14845 Davis Road, American Tire Exchange, PPR-22-38

Please accept the following comments from El Paso County Public Health regarding the 5.0-acre warehouse/storage/office project referenced above:

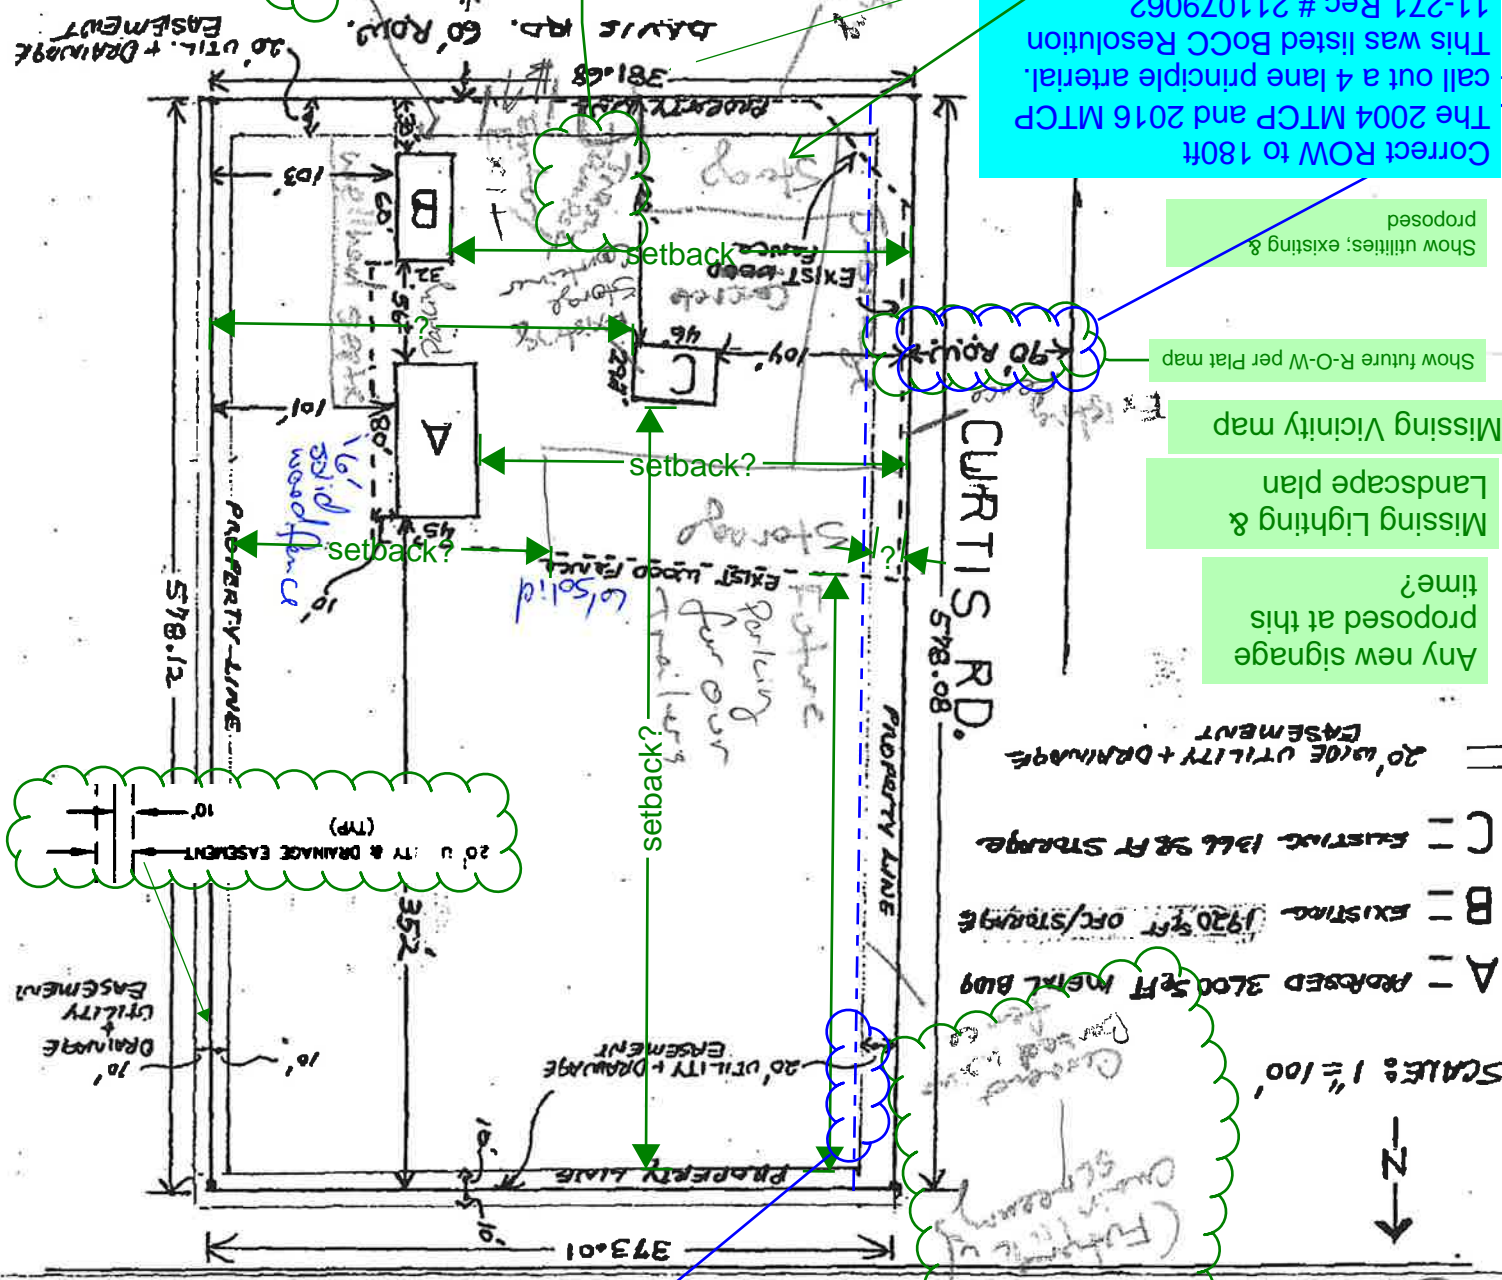
- Water service for the site is provided by an existing well.
- Wastewater service for the project is provided by an existing onsite wastewater treatment system (OWTS). The size and location of the OWTS is unknown at this time; however, a record of the system may be available at El Paso County Public Health. Therefore, prior to any construction or any onsite grading, all components of the OWTS (septic tank, building sewer lines, and the soil treatment area) must be located. Measures must be taken to protect all the OWTS components from damage by all vehicular traffic and the protection of a similar sized area for the possible repair or replacement of the existing soil treatment area, and to assure the soil treatment area is located 100' minimum from the well.

- A New OWTS Permit may be required for the office depending on the investigation of the OWTS permit and the approval of the system components.
